NORTH FALLS OFFSHORE WIND FARM DEVELOPMENT CONSENT ORDER

PINS REFERENCE EN010119

**DEADLINE 6: PORT OF LONDON
AUTHORITY'S COMMENTS ON THE
APPLICANT'S RESPONSE TO THE
EXAMINING AUTHORITY'S SECOND
WRITTEN QUESTIONS**

Deep Water Route Cable Installation Areas (Future Dredging Depths) Plan

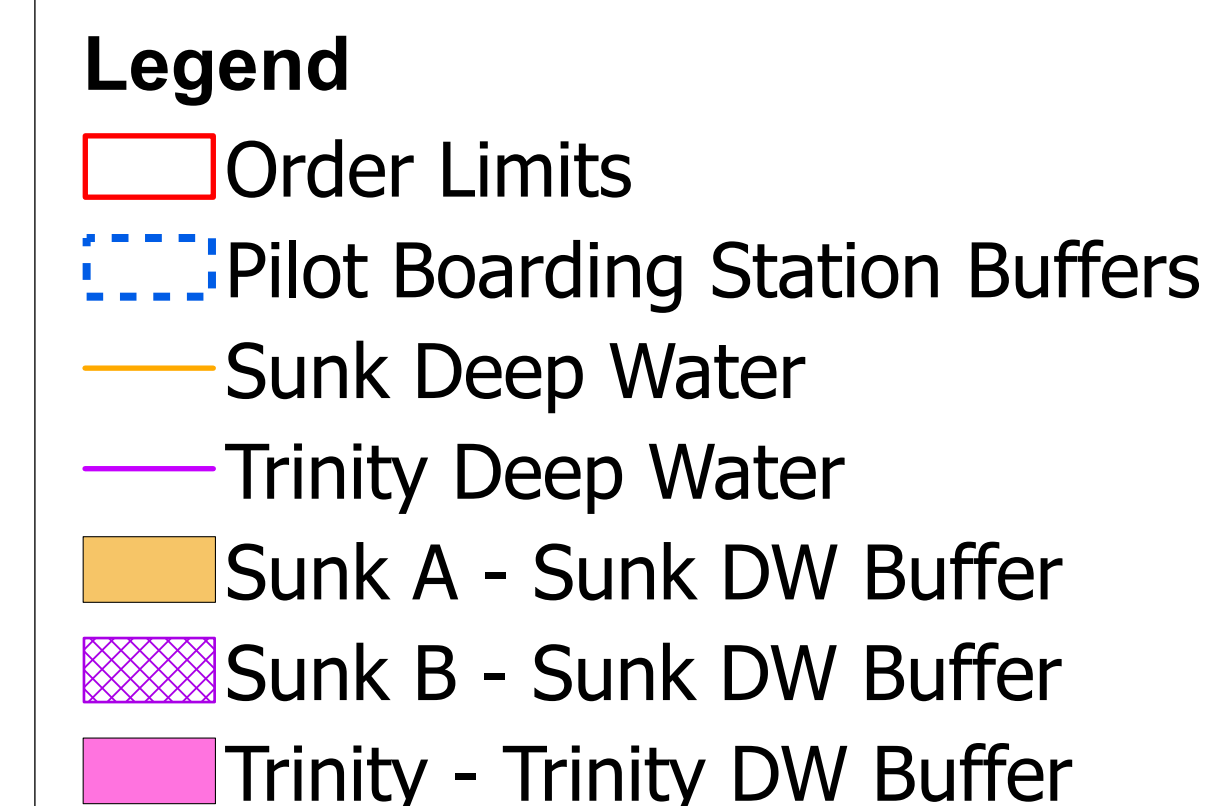
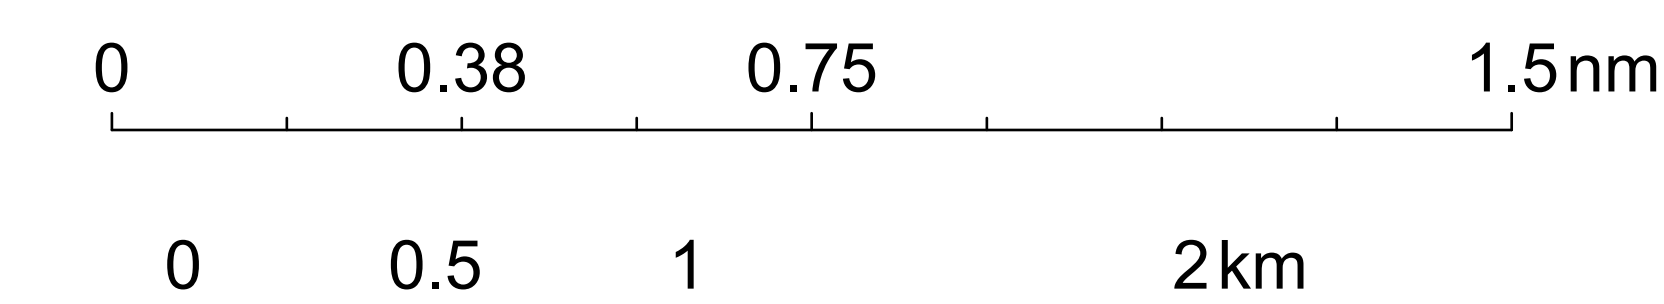
<p>following inspection by the PLA, it is identified by the PLA (and the same is notified to the undertaker as soon as reasonably practicable), that the level of cable is such that the paragraph 116 (a) has not been achieved or at any time following installation or maintenance the cable has moved such that the requirements of paragraph 116 (a) are no longer being achieved, then, unless otherwise agreed in writing with the PLA, the undertaker is required to carry out remediation works as specified in the cable specification and installation plan subject to paragraph 120 in relation to the Deep Water Routes.</p> <p>120.Unless otherwise agreed in writing with the PLA, the undertaker will carry out the following arrangements for the carrying out the remediation works:</p> <p>(1) the undertaker will re-bury the cables to the required specification to achieve the requirements of paragraph 116(a); and</p> <p>(2) Following the completion of the works in sub-paragraph (1), if it is identified by the undertaker or the PLA (following inspection) that the required specification is not achieved, then the undertaker will remove the cable without unreasonable delay and thereafter relay a new cable pursuant to an updated cable specification and installation plan which updated cable specification and installation plan specifically identifies and addresses why the previous cable burial was not successful, how that has been addressed and what measures are to be used in relaying the cable to prevent the failure reoccurring.</p> <p>(3) The undertaker will consult the PLA on the draft updated cable specification and installation plan required under sub-paragraph (2) and the provisions of both this paragraph and paragraph 117 will apply to that updated cable specification and installation plan .</p> <p>(4) The steps in this paragraph shall be repeated until the requirement in paragraph 116(a) is achieved or the cable is permanently removed from the Area of Interest.</p> <p>In the absence of protective provisions there needs to be a Requirement and a condition in the DML to deal with the above.</p> <p>If the PLA is also not being consulted on the design which could be a requirement of the protective provisions the Requirement should be amended as follows:</p> <p>"(3) Any part of Work No. 3 and any associated development <u>the authorised development</u> located within the following areas shown on the Deep Water Route Cable Installation Area (Future Dredging Depths) Plan, must be</p>

<p><u>designed</u>, installed, <u>operated</u> and maintained at a level which would not preclude dredging:</p> <p>(a) of the area shown shaded in orange and labelled Sunk A – Sunk DW Buffer, to a level of 22 metres below Chart Datum;</p> <p>(b) of the area shown shaded in pink and labelled Trinity – Trinity DW Buffer, to a level of 22 metres below Chart Datum; and</p> <p>(c) to the area shown cross hatched purple and labelled Sunk B – Sunk DW Buffer, to a level of 19 metres below Chart Datum.</p> <p><u>(4) The undertaker must not carry out wet storage or relocate any boulders or archaeological finds to or within the three areas referred to in paragraph (3)."</u></p> <p>3. The PLA's concerns are wider than cable burial and include pre-commencement and post construction monitoring and survey work</p> <p>As is common with the installation of cables a number of pre-construction activities including pre-construction surveys and monitoring may need to be carried out in order to obtain more information to inform for example, the final cable route and burial depth or to allow for the installation of the cable on the chosen route (e.g. boulder clearance, UXO clearance etc). These surveys are not necessarily licensable activities and the oNIP applies from the 'start of offshore construction activities' which is not clear as to when this is and it only relates to surveys where they are considered to involve RAM vessels.</p> <p>The PLA would want to at least be consulted on any surveys or monitoring (pre and post construction) and any pre-construction activities that affect the DWR because a survey vessel may pass slowly over the DWR or even stop to place/remove monitoring equipment which could affect shipping. Equally restrictions on how the pre-construction activity can be undertaken may need to be proposed e.g. a boulder or archaeological finds cannot be relocated to or within a DWR but must instead be removed.</p> <p>These surveys are not necessarily licensable activities and to the extent that the various mitigation plans deal with surveys, the final plans are only required to be approved in the DML pre-construction.</p>

Q16.0.7	The applicant	<p>Port of London Authority – Permanent impacts Could the applicant advise to what extent has the socio-economic assessment in Environmental Statement Chapter 31 [APP-045] considered the concerns raised by the Port of London Authority [REP2-056] regarding permanent impacts, resulting from cable depths and interaction with third party schemes at cable crossings?</p>		<p>It should be noted that the cable crossing locations known at this time are stated in the Export Cable Crossing Zone Plan [REP1-059].</p> <p>By comparing the red-line boundaries (RLBs) of the various projects, it should be clear that there are to be no crossings within the DWRs (the RLBs of the projects do not overlap in these areas), and the intention of the Export Cable Crossing Zone Plan is to show that any crossing of Five Estuaries would take place away from the Sunk Pilot Diamond due to water depth reasons. Therefore, there would be no impacts from crossings on the ability of a 20m draft vessel to access port.</p> <p>The crossing zones shown Export Cable Crossing Zone Plan are indicative because all projects which the Applicant is crossing are still in development stages and hence have not got a fixed location of their infrastructure on the seabed. Therefore, the Export Cable Crossing Zone Plan assumes that the cables being crossed could be anywhere within the indicated zone. It should be noted that the zone extends outside the respective project boundaries as the grade-in/grade-out distances (to bring the cable to the seabed) need to be considered. As the cable location could be anywhere within the boundary, the Applicant may need protection to extend beyond that to allow for the grading in/out of the Applicant's cable and associated protection.</p>	<p>The PLA is concerned that the Applicant will not commit to no cable crossings in the DWR. What is shown in the export cable crossing zone plan is indicative. The PLA has requested on more than one occasion for the Applicant to commit to no crossings in the DWR. If as the Applicant is saying it is clear that there are to be no crossings within the DWR's and away from the Sunk Pilot Diamond then the Applicant should be able to provide this commitment.</p> <p>The Applicant's position is contrary to the position set out in the oNIP (S3.1.6) which states:</p> <p><i>"There is an expectation that cable crossings will be required, most notably with the export cables for Five Estuaries, Sealink and Neuconnect. The indicative zones for such crossings has been shown in the Export Cable Crossing Zone Plan [REP1-059], which shows they will be outside of the DWR areas. As with cable burial or protection, any cable crossings in proximity to the DWRs will be designed so as to again ensure dredging is not restricted within the DWR areas defined in 9.57 Deep Water Route Cable Installation Areas (Future Dredging Depths) and the CSIP."</i></p> <p>For the first time the Applicant is saying <i>"It should be noted that the zone extends outside the respective project boundaries as the grade-in/grade-out distances (to bring the cable to the seabed) need to be considered. As the cable location could be anywhere within the boundary, the Applicant may need protection to extend beyond that to allow for the grading in/out of the Applicant's cable and associated protection."</i> This highlights the need for the areas for deeper cable burial that are to be shown on the Deep Water Route Cable Installation Area (Future Dredging Depths) Plan to be agreed without delay.</p>
